SUBJECT: Triangle Expressway Southeast Extension (Complete 540) from NC 55 Bypass in Apex to US 64/264 (I-87) in Knightdale, Wake and Johnston Counties; Federal Aid No. STP-0540(19), STP-0540(20), and STP-0540(21); WBS Nos. 37673.1.TA1, 35516.1.TA1, and 35517.1.TA1; STIP Project Nos. R-2721, R-2828, and R-2829

Subject: R2721A, Permit Modification Request 14, Middle Creek Temporary Trestle Removal, Permit Site 14

**North Carolina Division of Water Resources
Transportation Permitting Branch
In-Field Minor 401 Water Quality Certification Modification**

Project Name/ TIP Project No.: **R-2721A**; NC Hwy 540_ Date: January 22, 2024

PROJECT REFERENCE NO.		SHEET NO.	
R-2721A		9	
R/W SHEET NO.			
ROADWAY DESIGN ENGINEER		HYDRAULICS ENGINEER	
DOCUMENT NOT CONSIDERED FINAL UNLESS ALL SIGNATURES COMPLETED

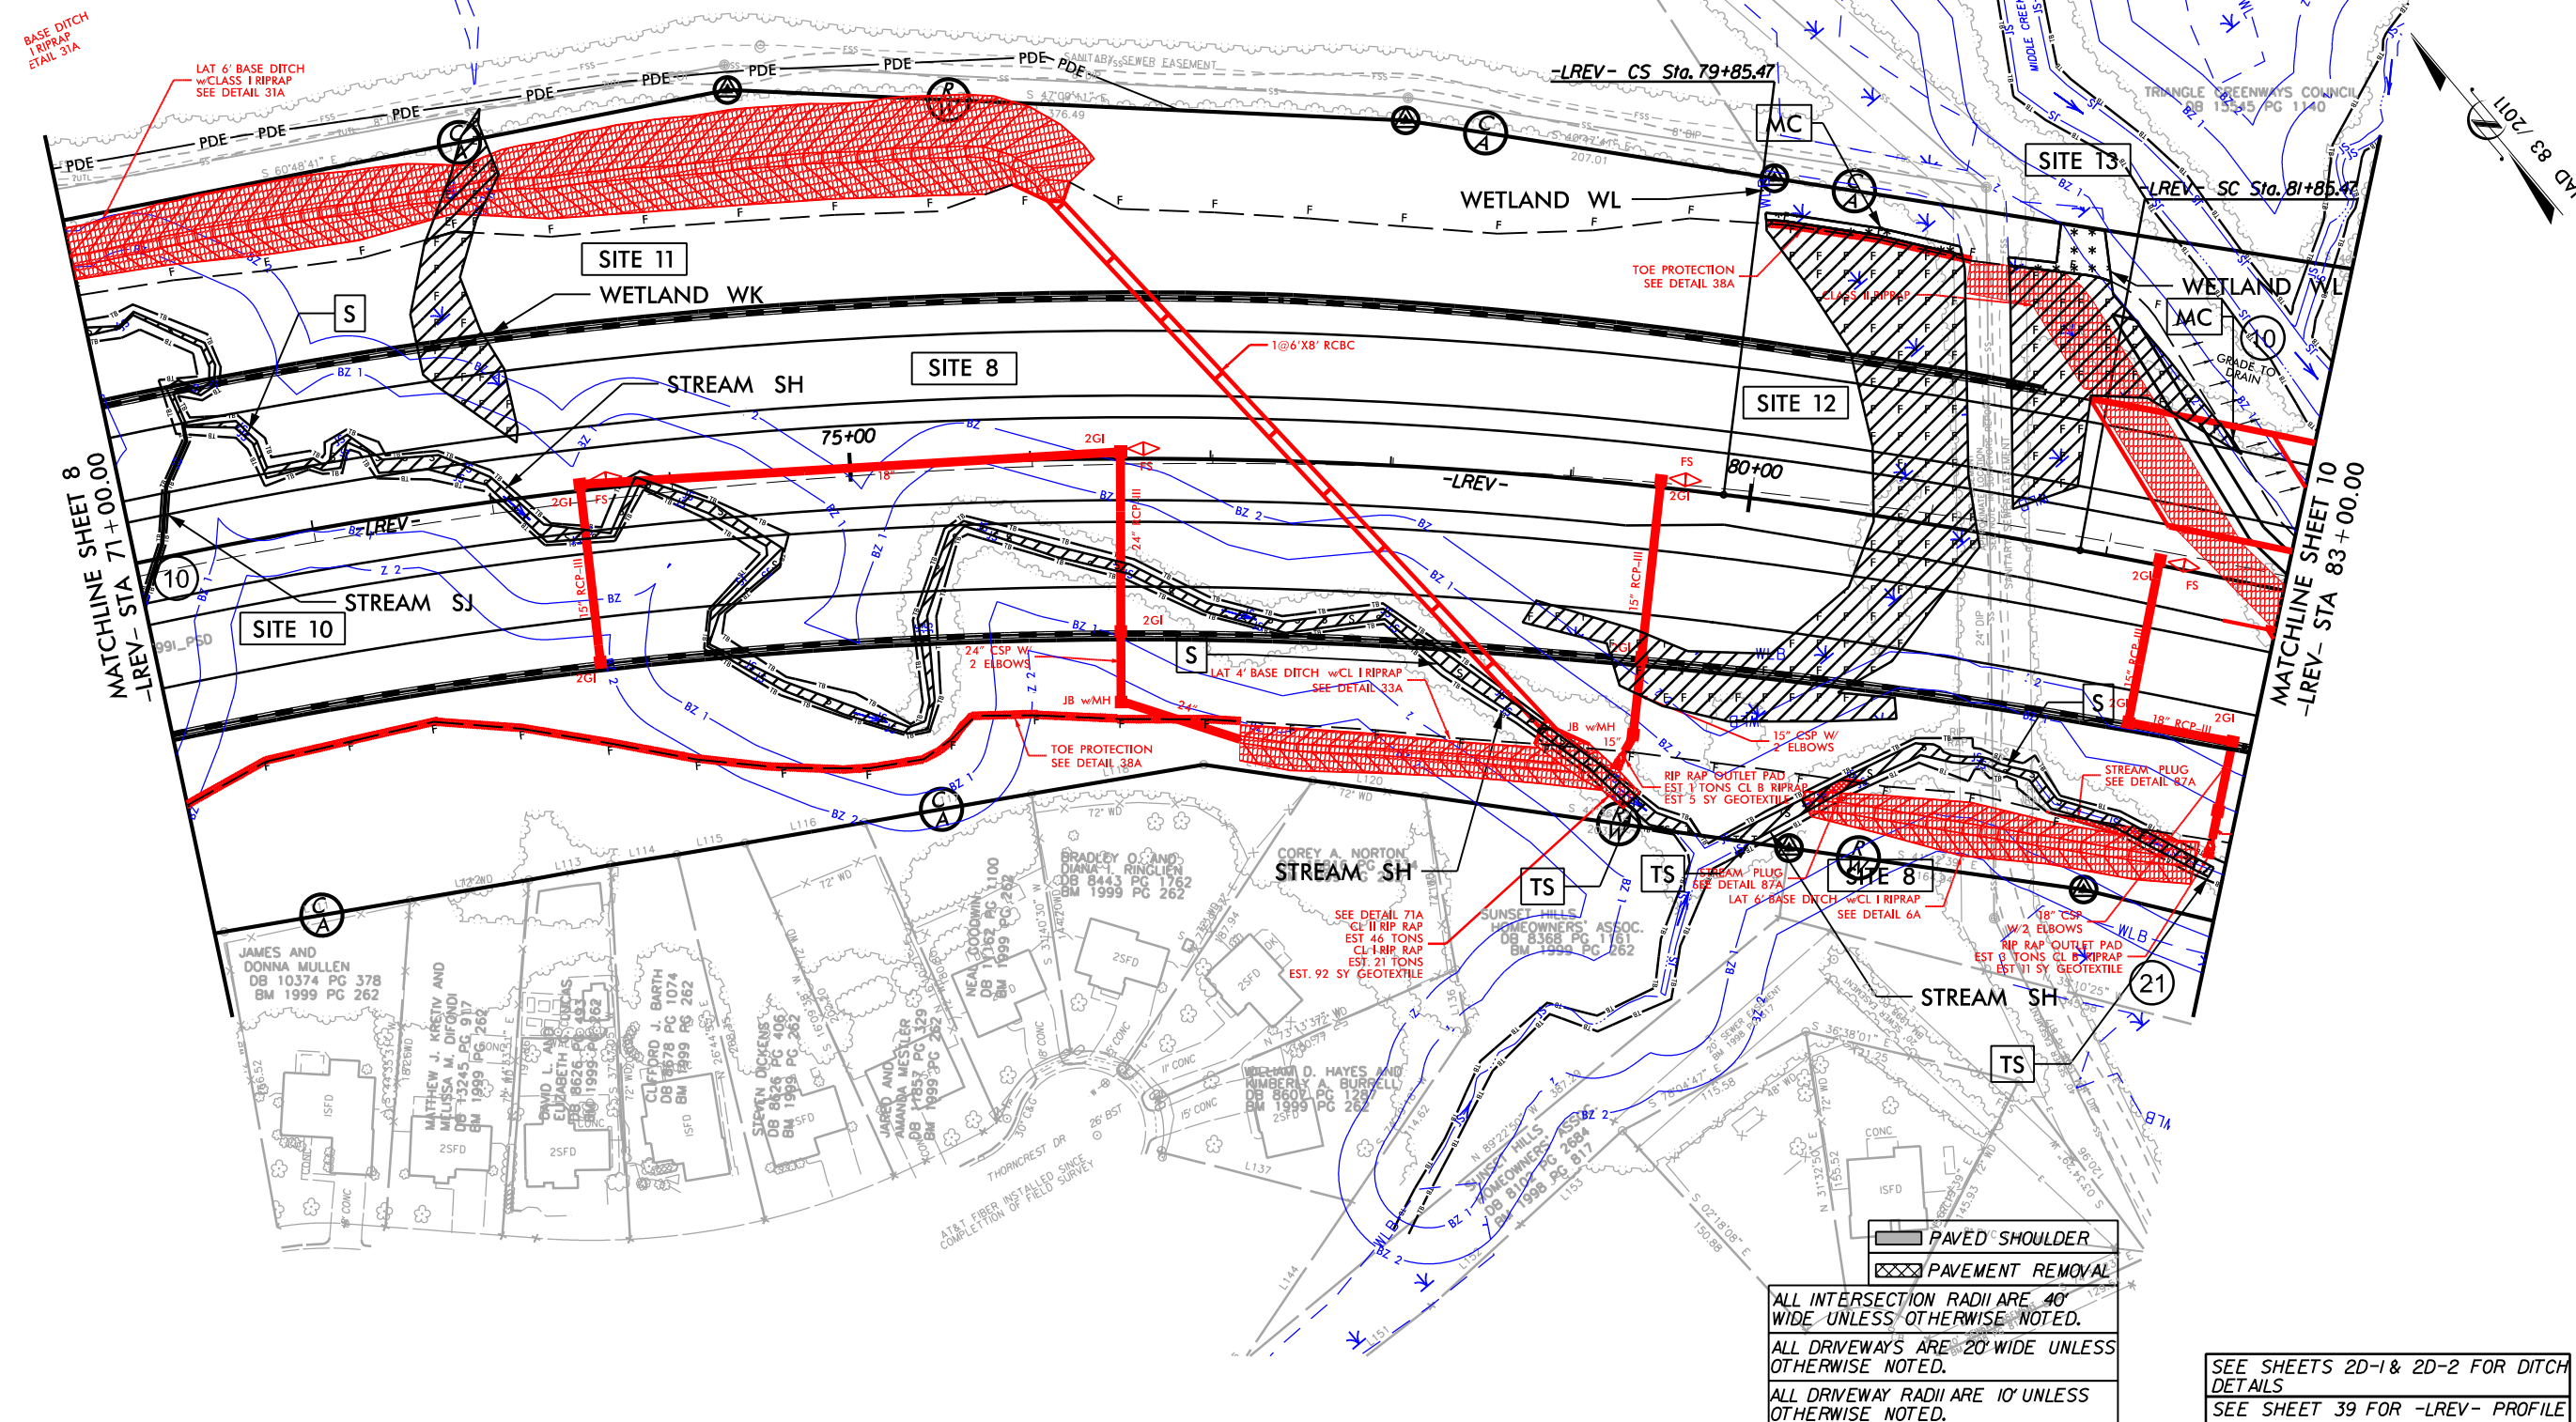
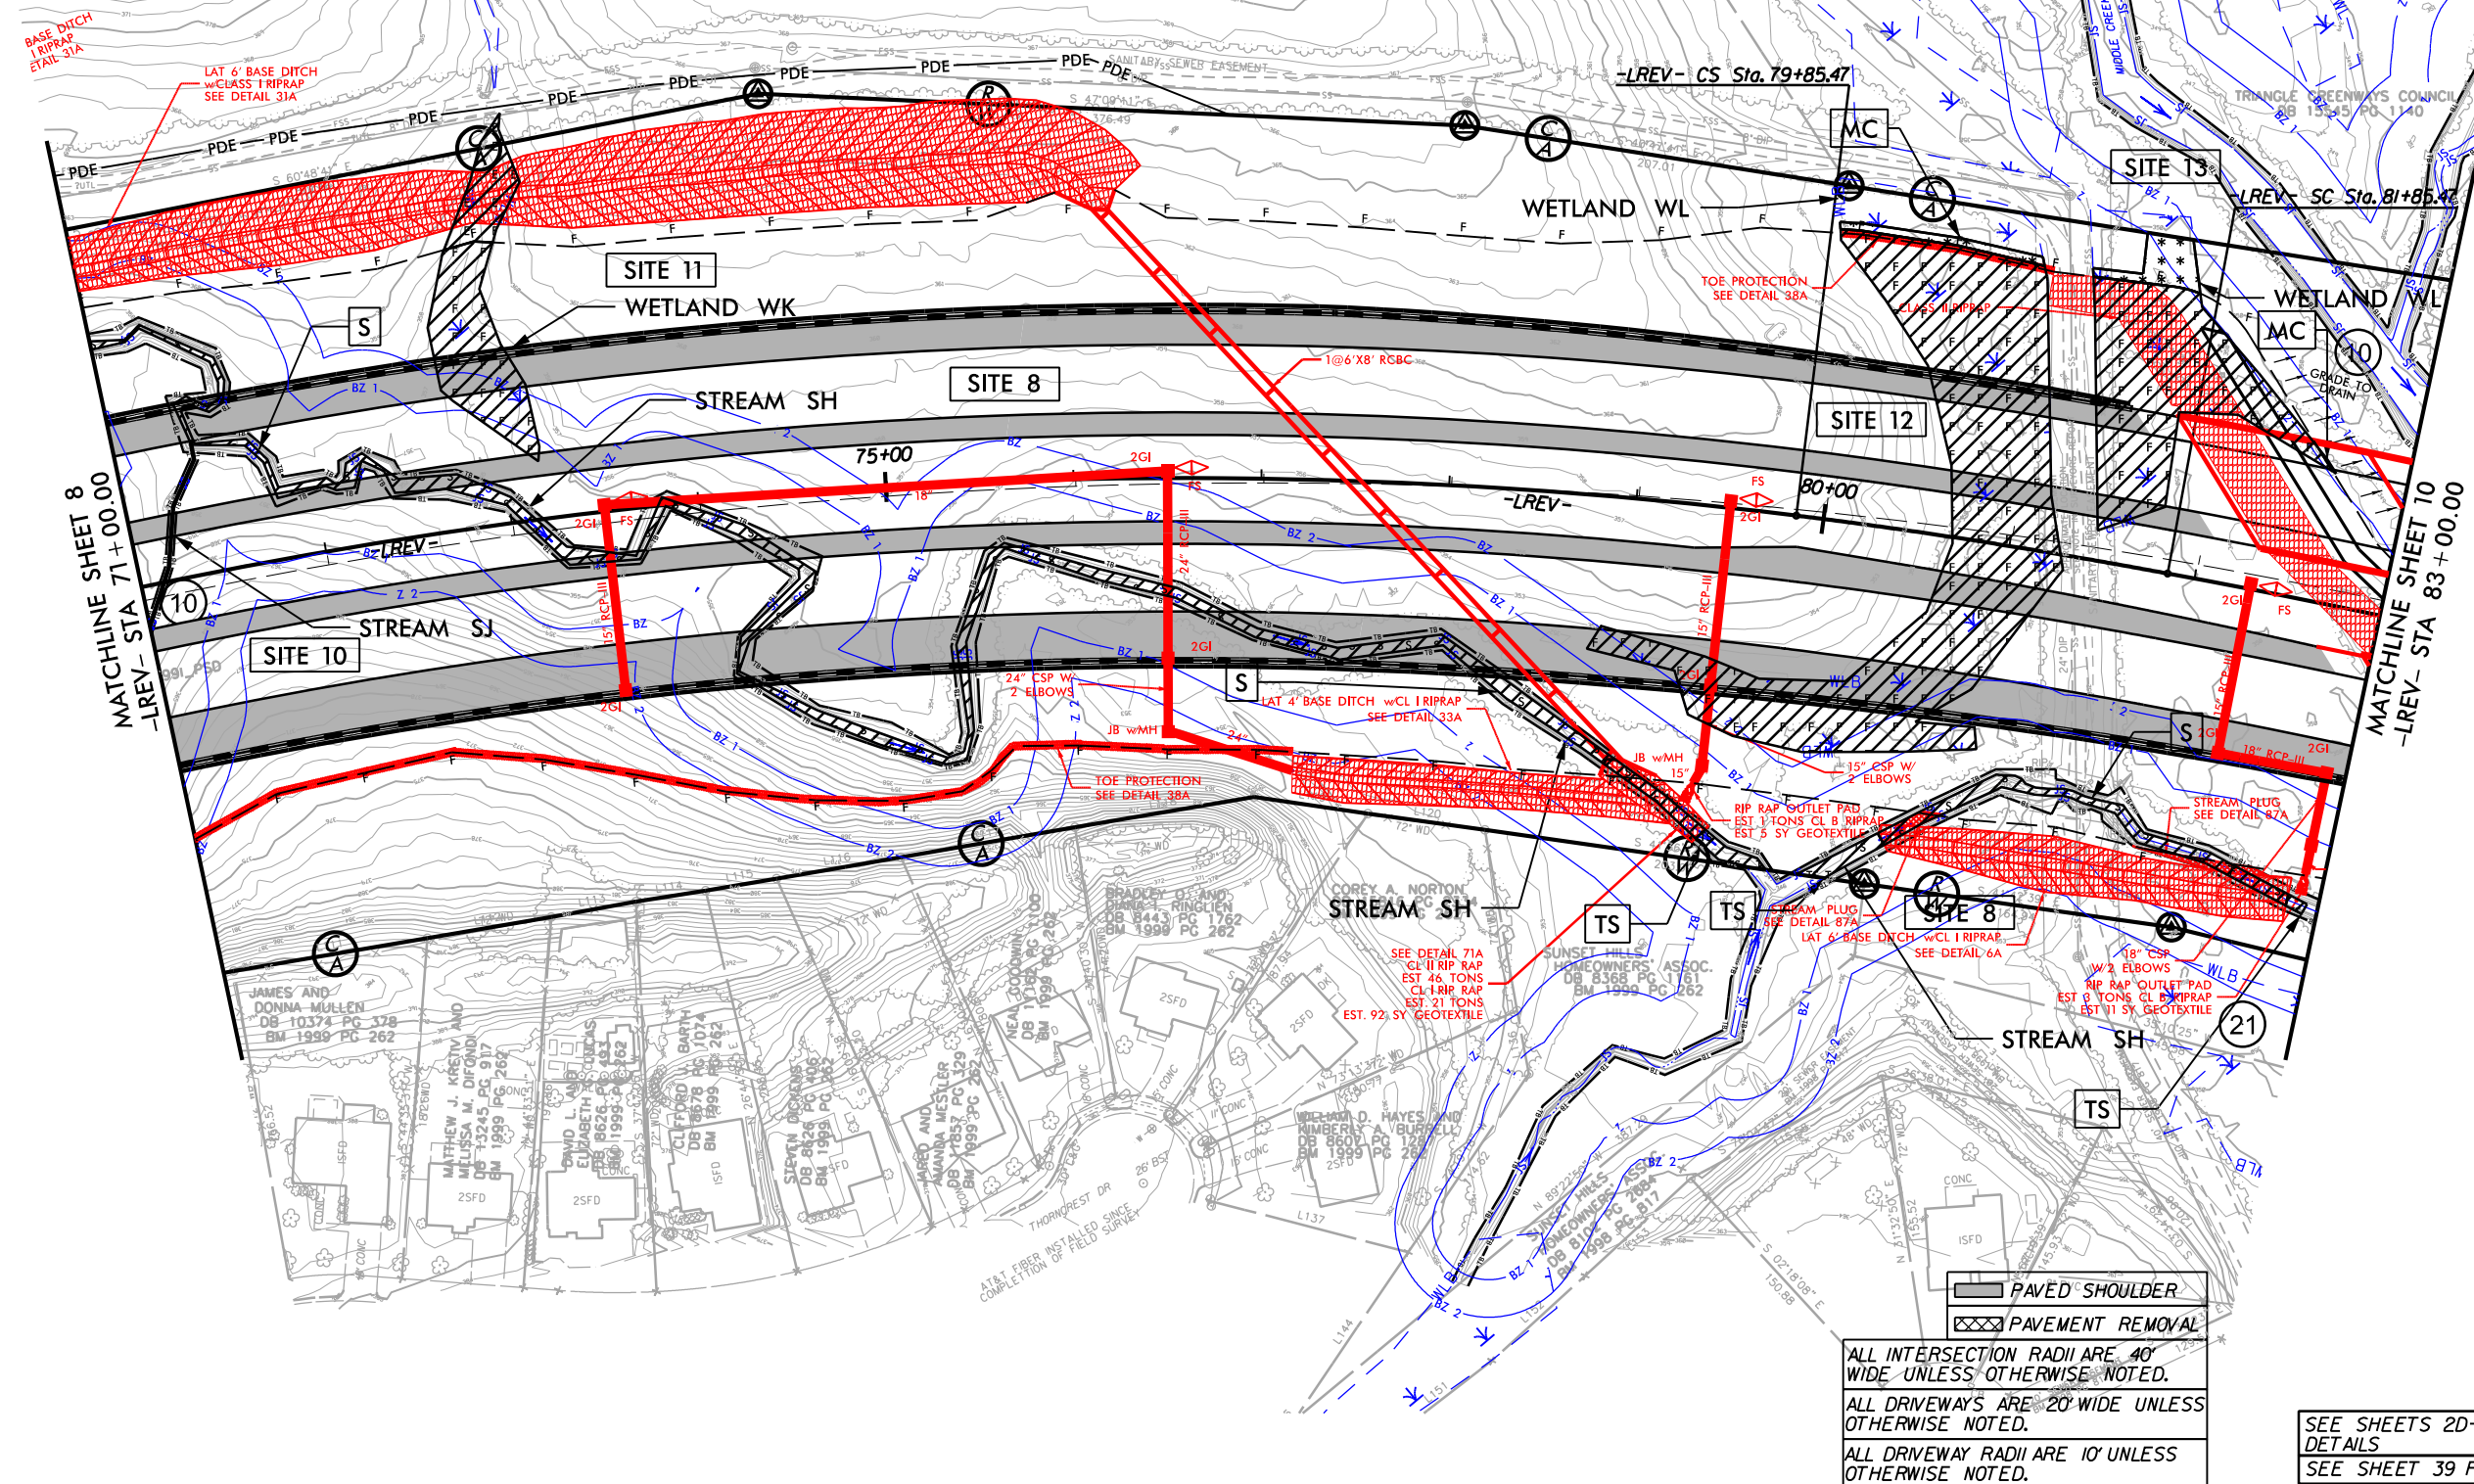
This email is a request for a modification to the R2721A section of the Complete 540 project which will add impacts at Site 14 for the removal of the temporary work trestle bridges and bank stabilization of Middle Creek. The steep, nearly sheer banks on Middle Creek have further destabilized under the temporary work trestles.

The temporary work trestles were installed over Middle Creek for the construction of the permanent bridge structure at Permit Site 14. During the intervening years, material has built up under the temporary work structure, both on the fabric and plywood installed on the underside of the bridge which prevent sediment and other materials from being deposited into Middle Creek. The contractor fears that during the removal process, this collected material is at risk of falling into Middle Creek. Therefore, the contractor would like to install a temporary bypass diversion to ensure that nothing is displaced into the active flowline during the removal of the work trestle spans. The proposed temporary impact is 110 LF (0.05 ac) of stream channel. The attached sequencing plan includes the details for the pump around, including the placement of the dikes and silt bag.

During a recent field reconnaissance, we reviewed the need for some additional bank stabilization, which has been discussed with you both in previous agency compliance visits. The slopes have continued to slough due to high velocity flows and minimal vegetation, as well as the steepness and deeply incised state of Middle Creek. Therefore, 155 LF (0.04 ac) of permanent bank stabilization is proposed between the drip lines of the temporary work trestle structure. The contractor intends to use Class I rip rap which will be keyed into the bank, but not across the thalweg of the channel. While a permanent impact, this is not a permanent loss of function.

Site 14: The temporary work trestles were installed over Middle Creek for the construction of the permanent bridge structure at R-2721A Permit Site 14. During the intervening years, material has built up under the temporary work structure, both on the fabric and plywood installed on the underside of the bridge which prevent sediment and other materials from being deposited into Middle Creek. The contractor fears that during the removal process, this collected material is at risk of falling into Middle Creek. Therefore, the contractor would like to install a temporary bypass diversion to ensure that nothing is displaced into the active flowline during the removal of the work trestle spans. The proposed temporary impact is 110 LF (0.05 ac) of stream channel. The sequencing plan (*attached to the modification request*) includes the details for the pump around, including the placement of the dikes and silt bag.

During a recent field reconnaissance, we reviewed the need for some additional bank stabilization, which has been discussed in previous agency compliance visits. The slopes have continued to slough due to high velocity flows and minimal vegetation, as well as the steepness and deeply incised state of Middle Creek. Therefore, 155 LF (0.04 ac) of permanent Bank Stabilization is proposed between the drip lines of the temporary work trestle structure. The contractor intends to use Class I rip rap which will be keyed into the bank, but not across the thalweg of the channel. While a permanent impact, this is not a permanent loss of function.

The Corps has completed the evaluation of your request and has determined that it is appropriate and reasonable, and that no public notice is required for this modification. Therefore, the permit is modified as requested and as shown on the attached drawings. No additional compensatory mitigation is required.

Temporary Dewatering of 110 linear feet of perennial stream. Add additional 155 linear feet of bank stabilization (class I riprap). Change is at R-2721A, Site 14. NO additional mitigation is required.
